DATE: October 2, 2019

TO: Kari Parsons, PCD-Project Manager

FROM: Kyle R. Campbell, P.E. – Division Manager

SUBJECT: Response to “**PUDSP-19-004 – Midtown Collection at Hannah Ridge Second Submittal**”, dated September 9, 2019

DESIGNED BY	KRC	SCALE	DATE	03/22/19
DRAWN BY	KC	(H) 1" = 40'	SHEET	2 OF 5
CHECKED BY	(V) 1" = N/A	JOB NO.	1116.30

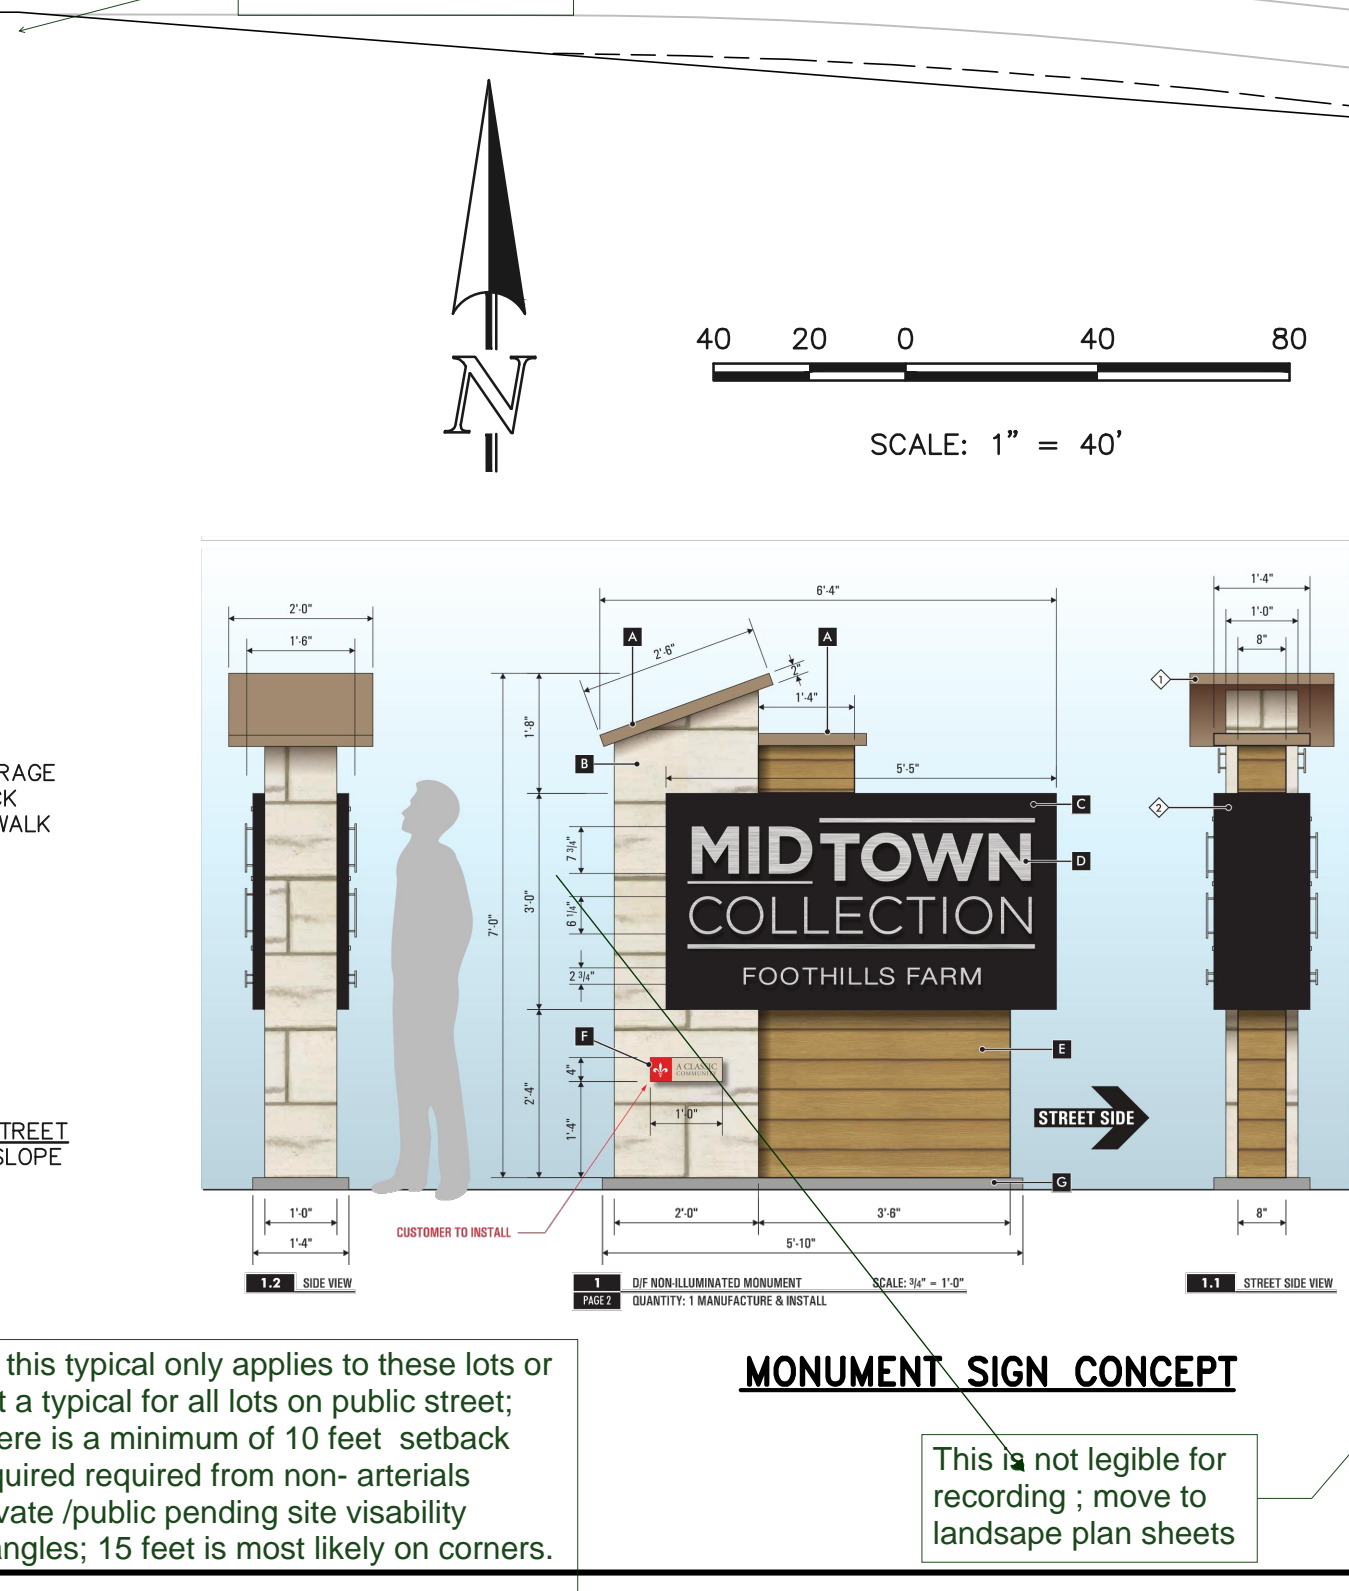
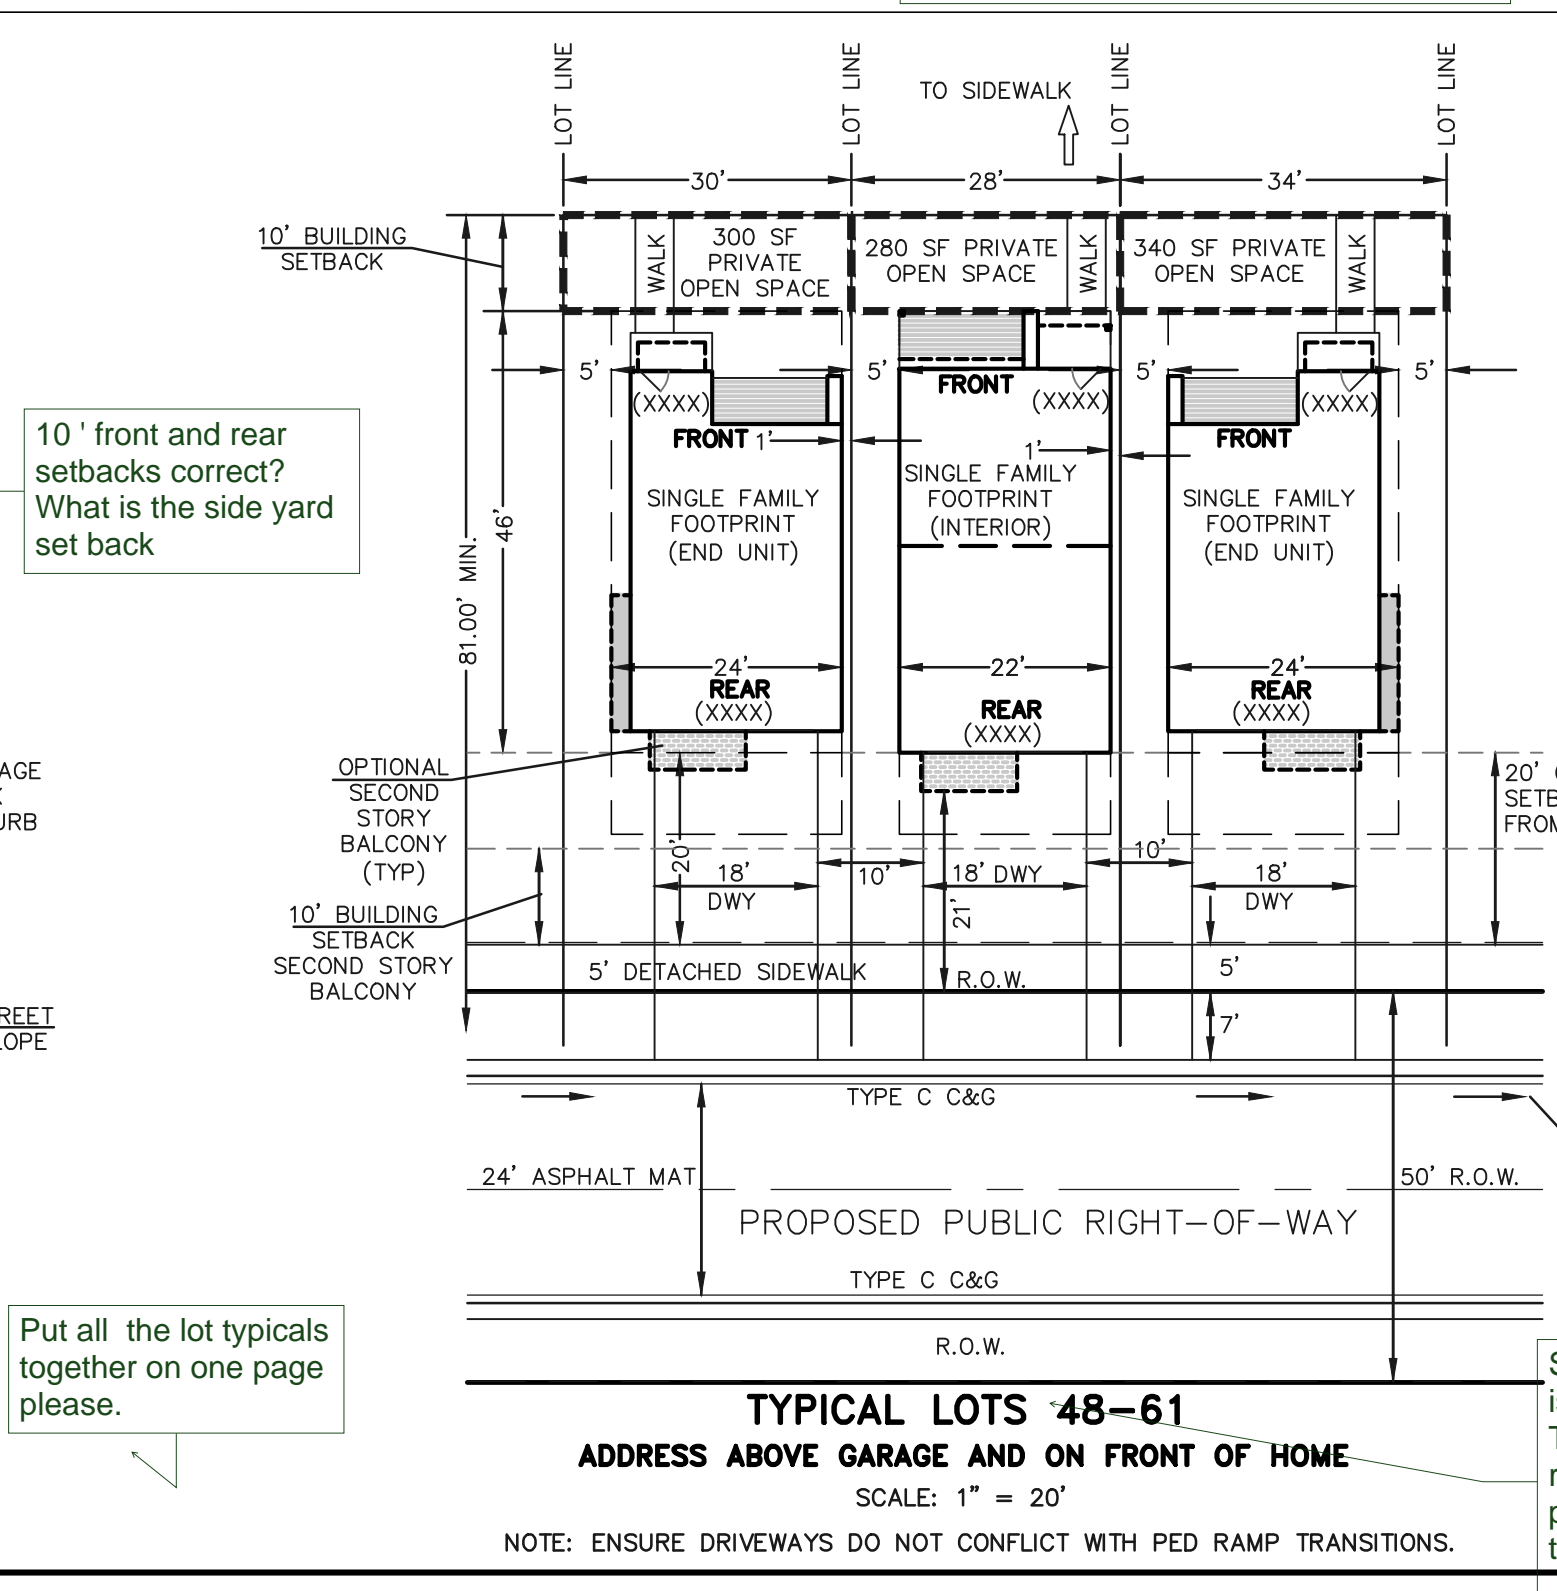
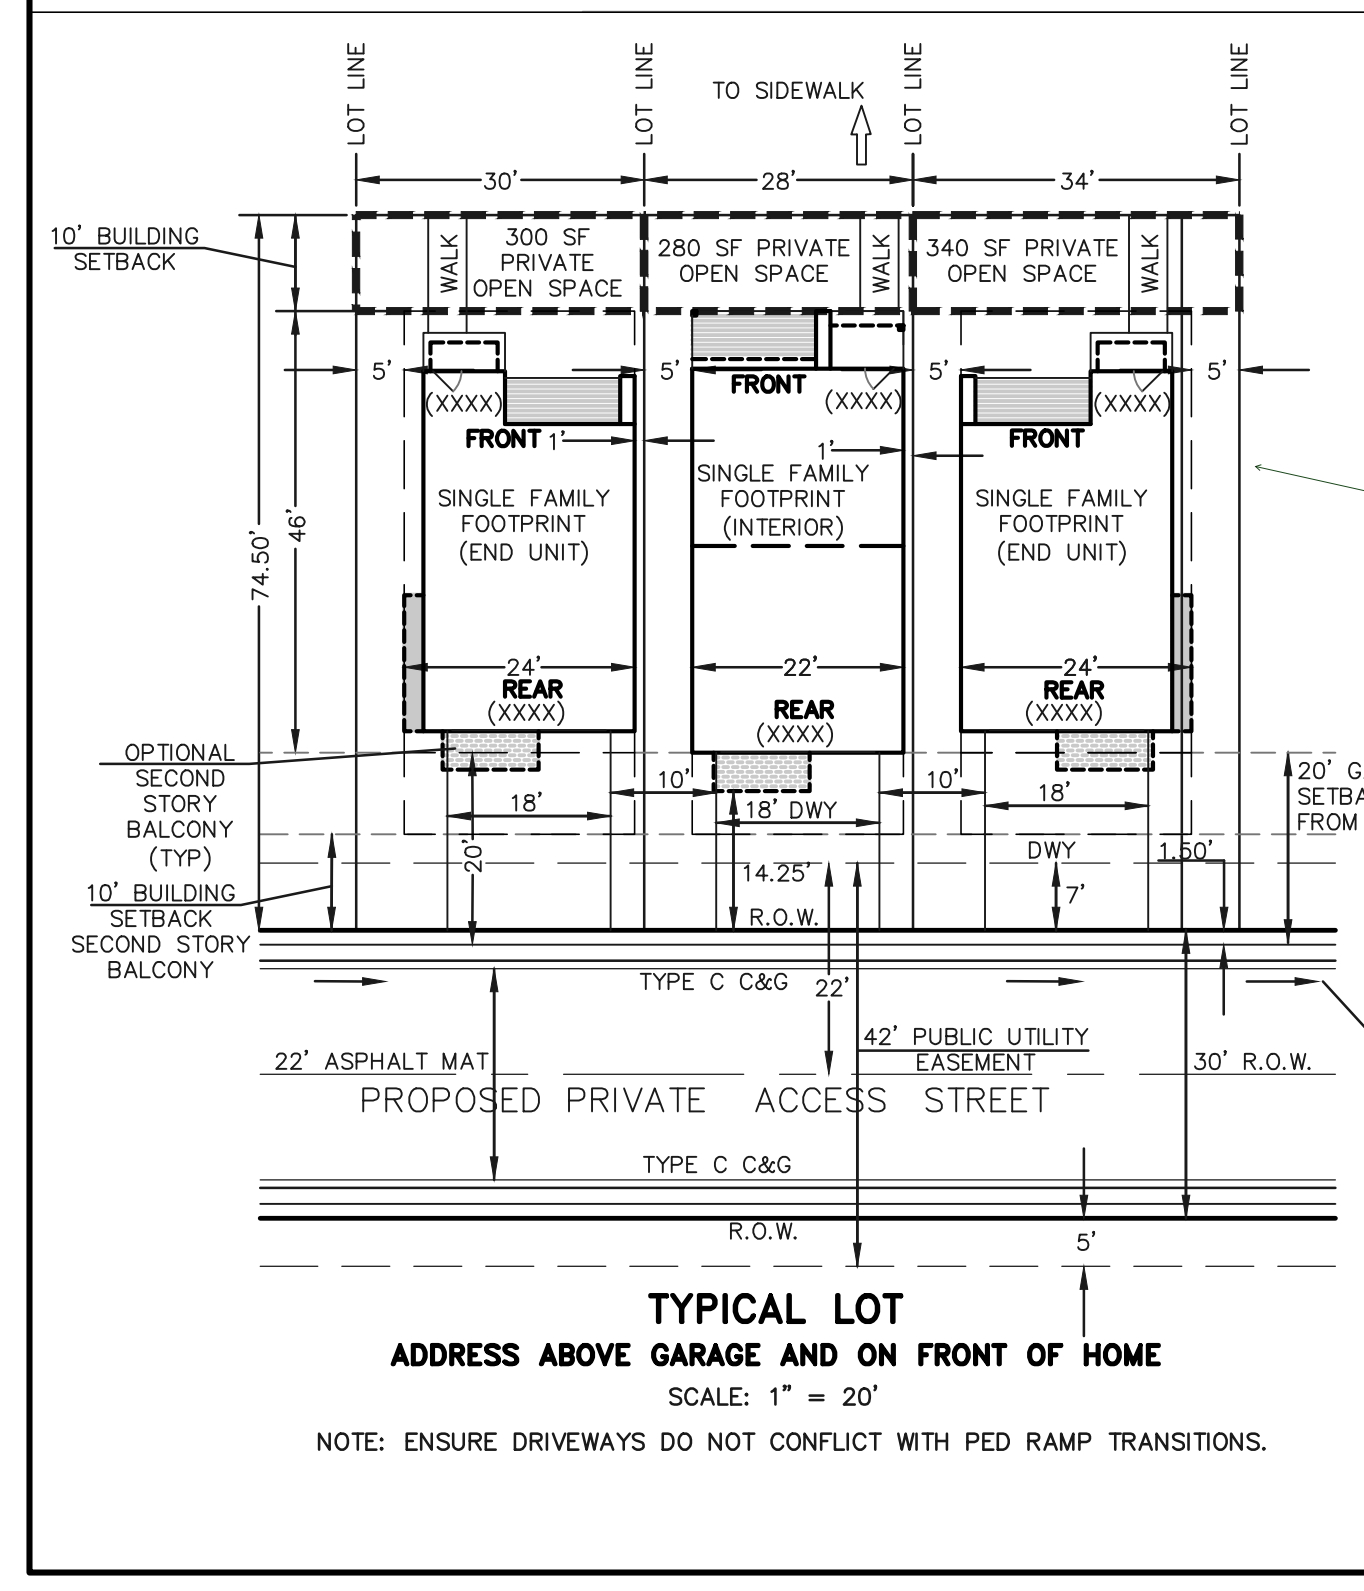
1. **through 3 – Resolved.**
4. See PUD-SP electronic redlines for additional comments. **Partially resolved; see updated/remaining redlines.**

**RESPONSE: Sheet 2 - “setback” added to Typical Lot Detail for clarity. The Garage is not within the 20’ setback, allowing for a 20’ driveway. The optional second story balcony is the item the comment was pointing. Sheet 4 – Drainage Easements and labels were added as requested. Access roads added to maintain ponds and existing rip-rap / headwall structure.**
